Application No: EP/5/21/HH
Site Address: Shore House Seafield Road East Preston BN16 1NA
Description of works: Detached garage extension with new pitched roof to create first floor self contained annexe & detached office outbuilding.

OWPC34184

I am commenting on behalf of the East Preston and Kingston Preservation Society.

PROPOSED NORTH ELEVATION 1:100
(including Shore House)

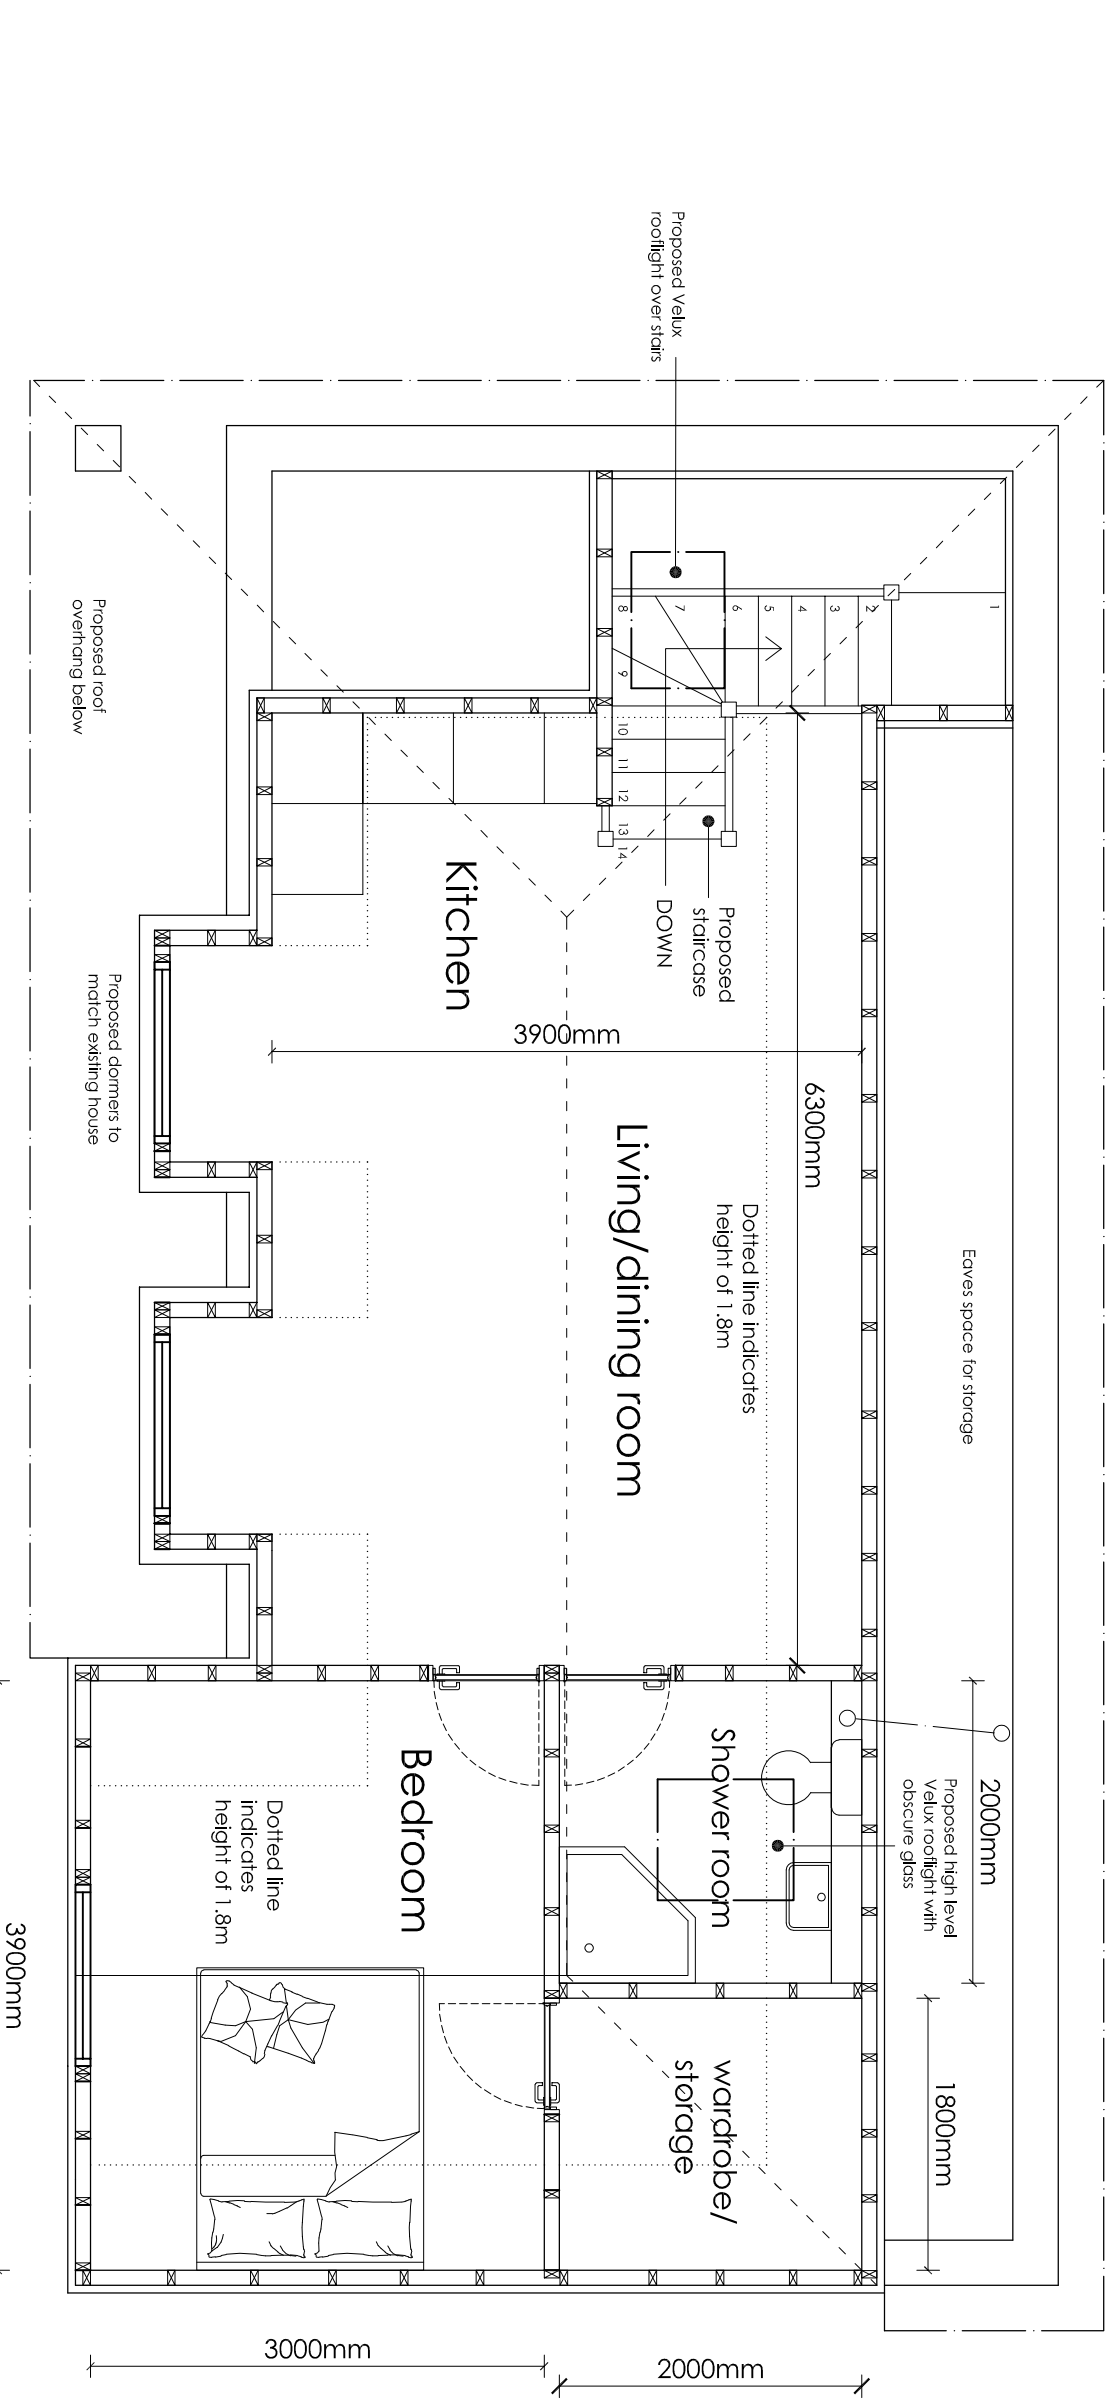
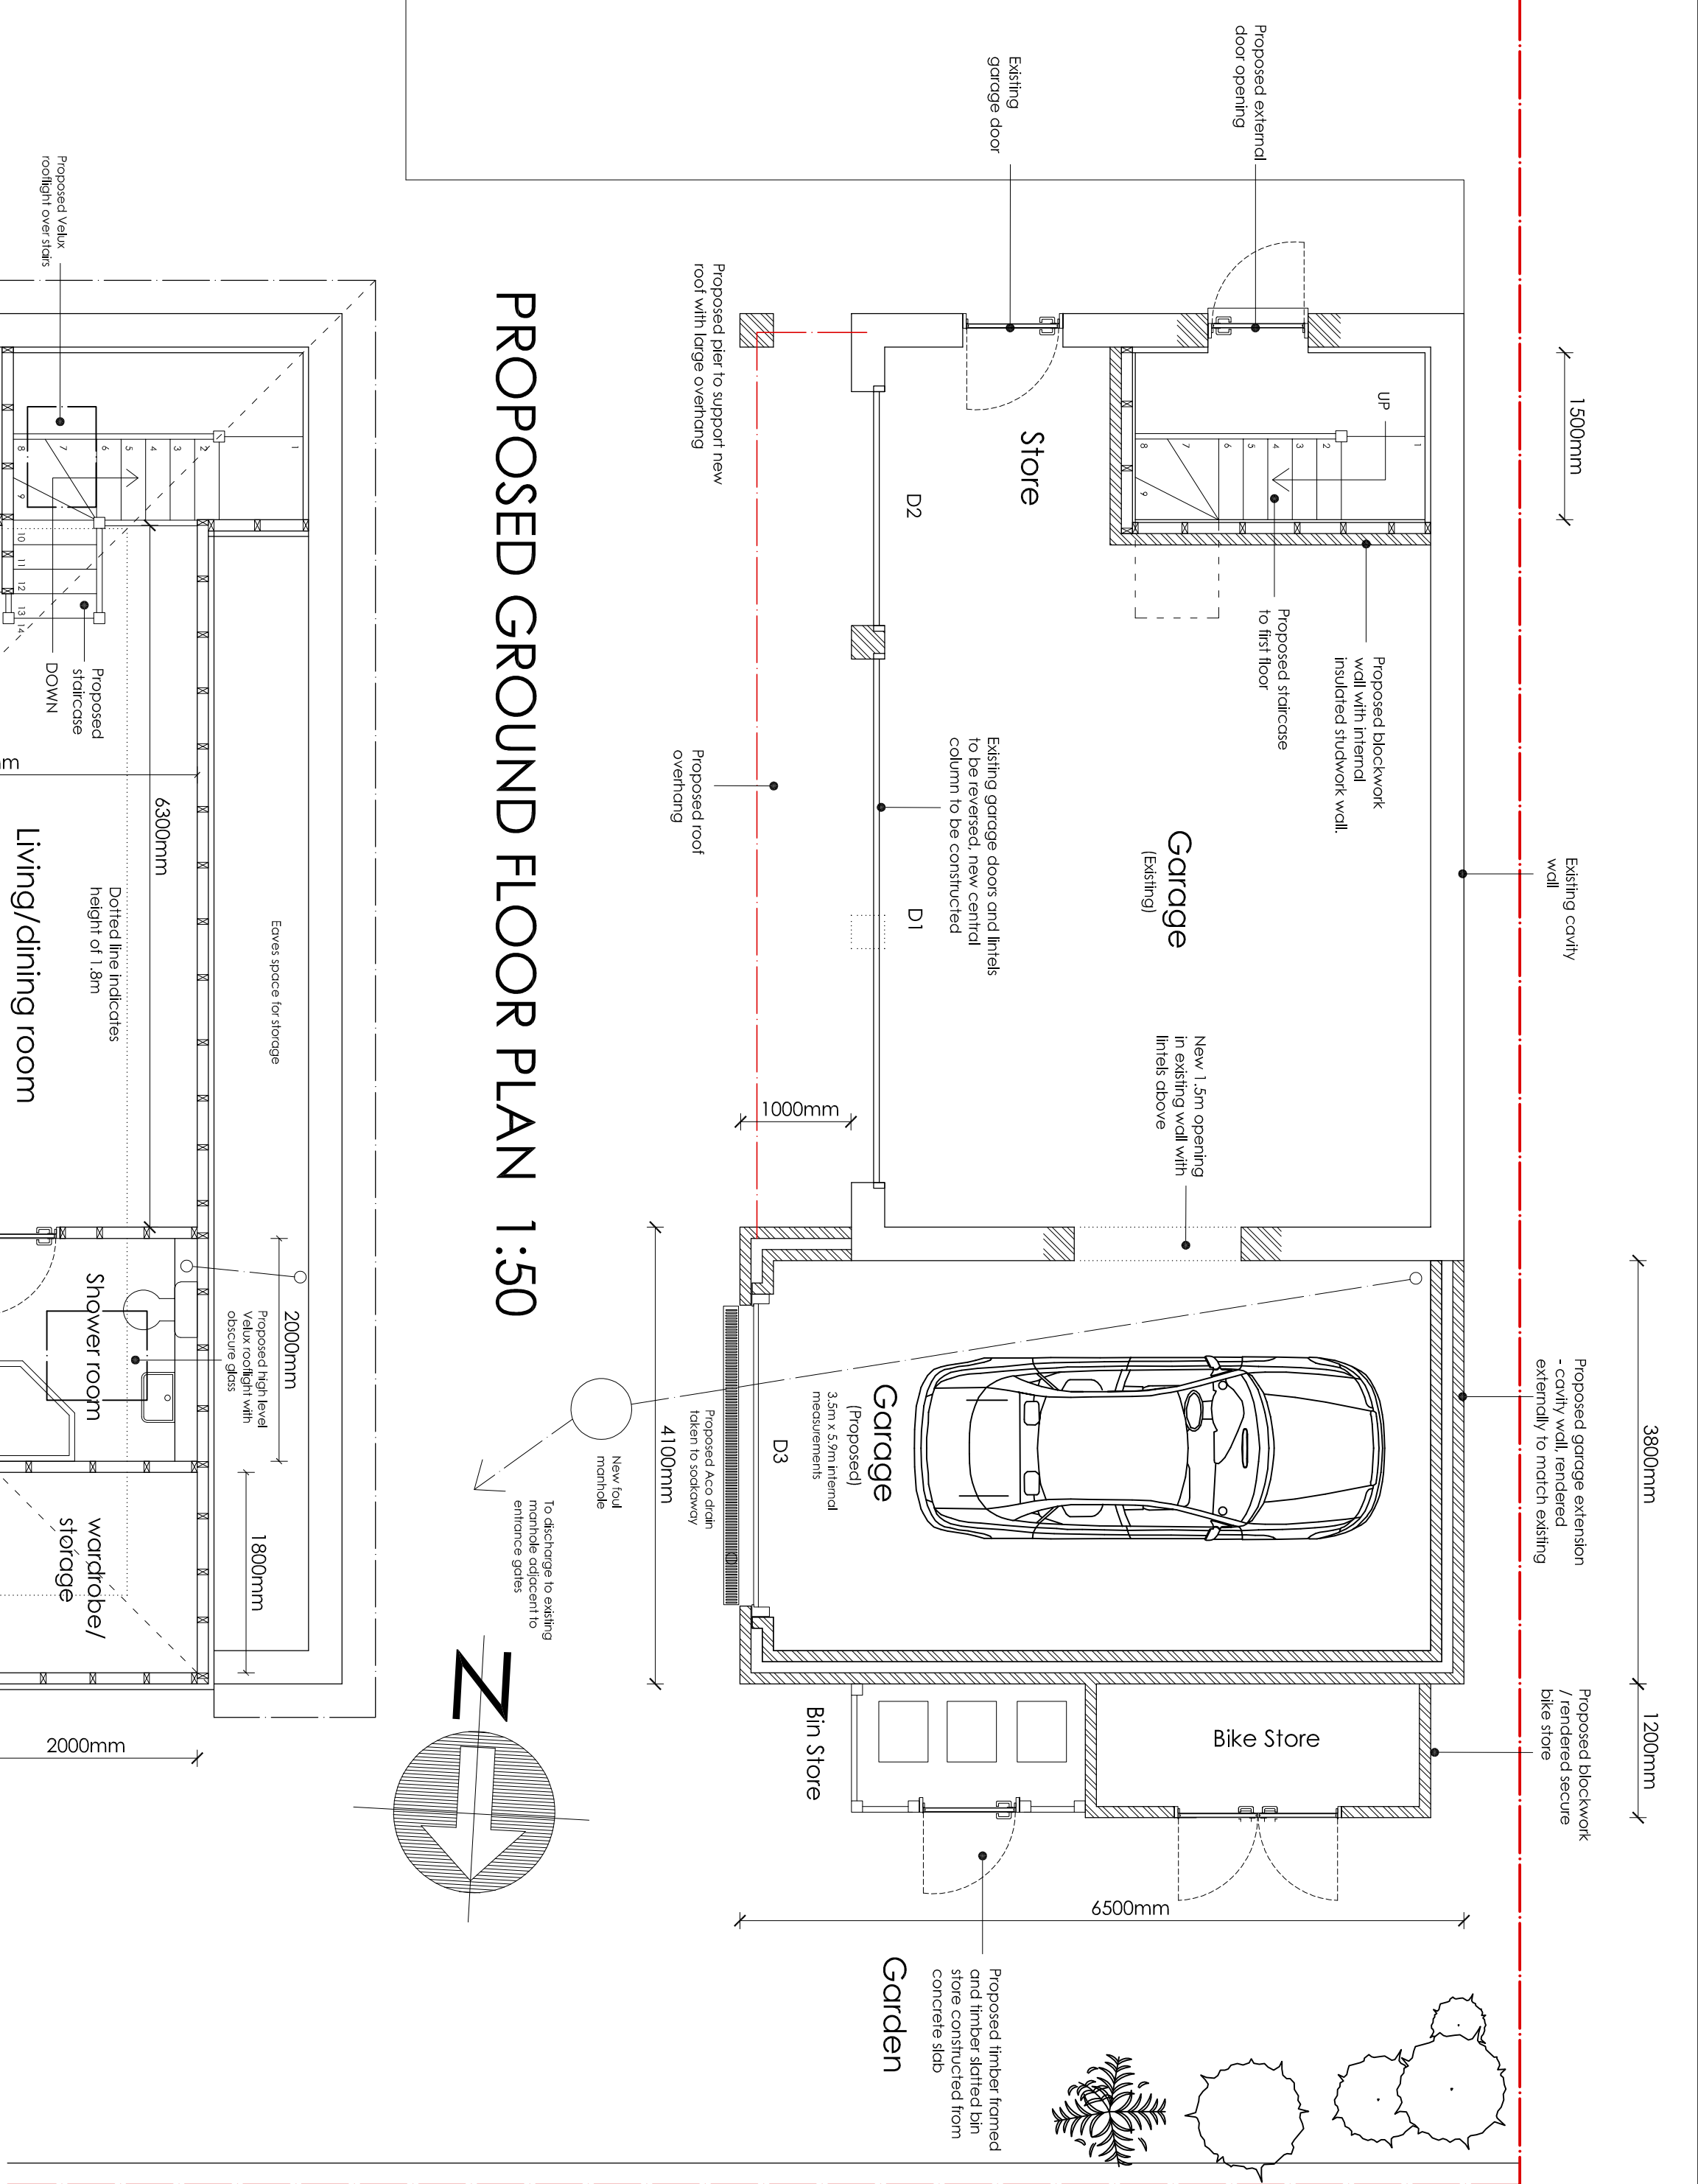
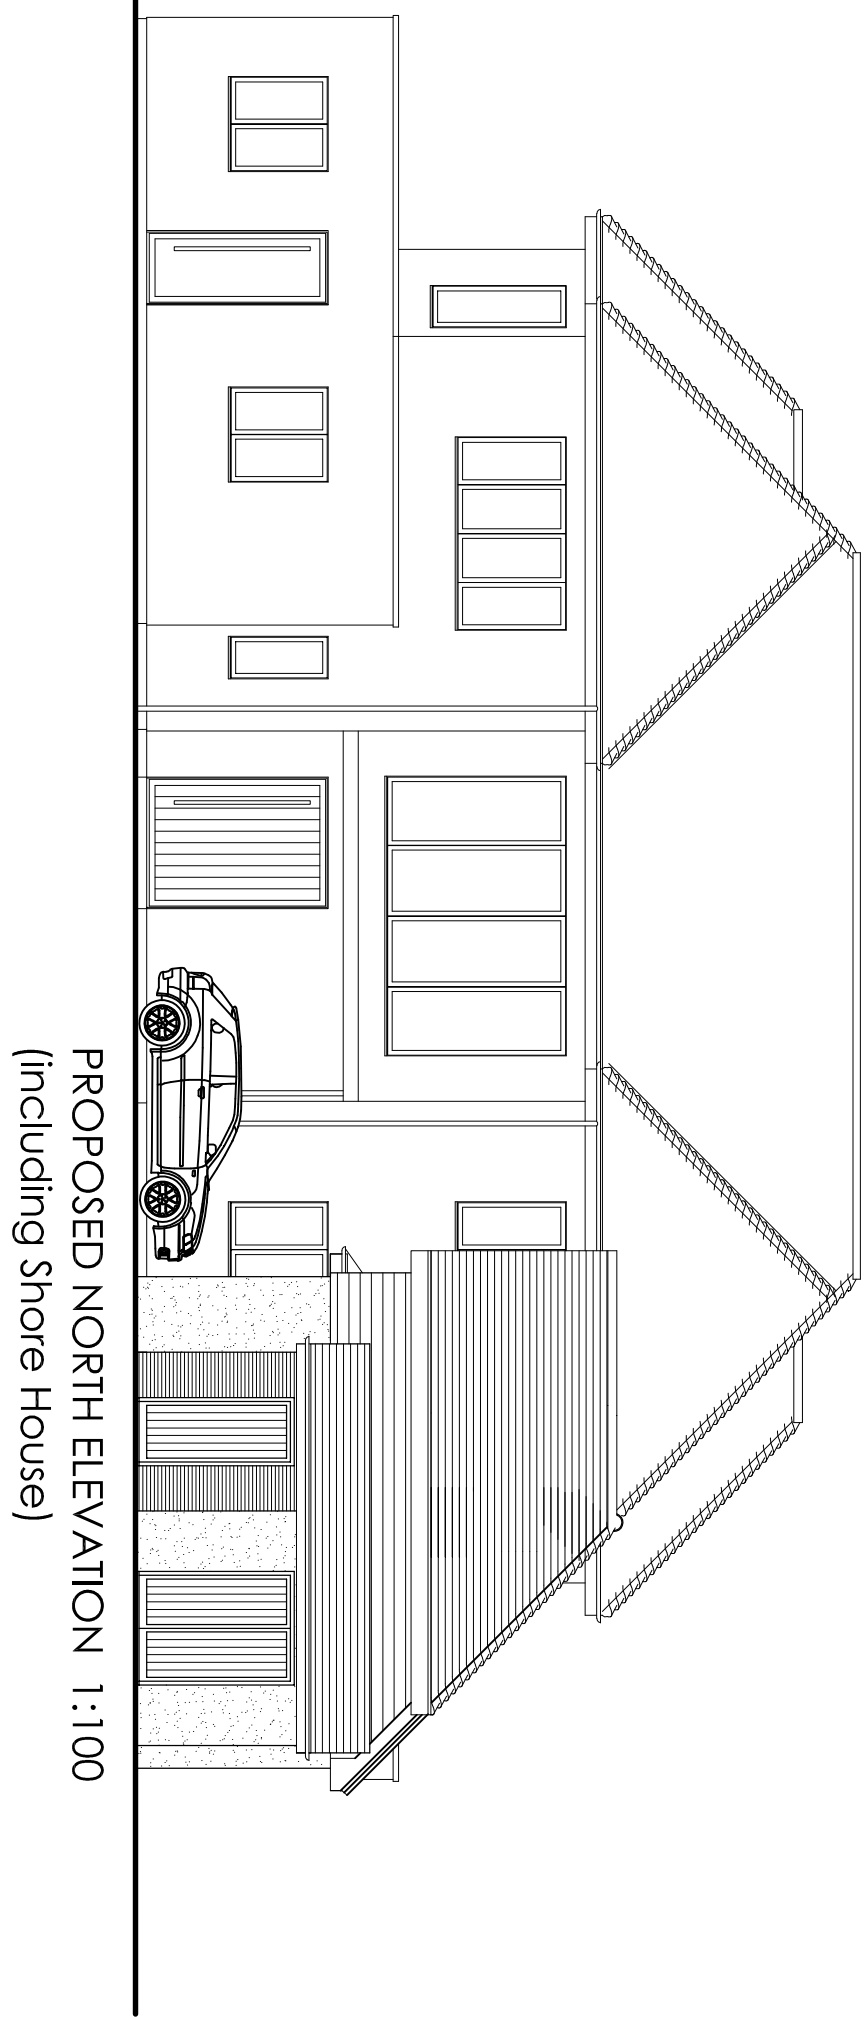
This development would place a two storey building 2.8 metres from the front boundary of the plot. The street frontage of the building would be especially unattractive, featuring the bin storage and the cycle shed. The building, because of its position, would have a significantly harmful effect on the street scene.
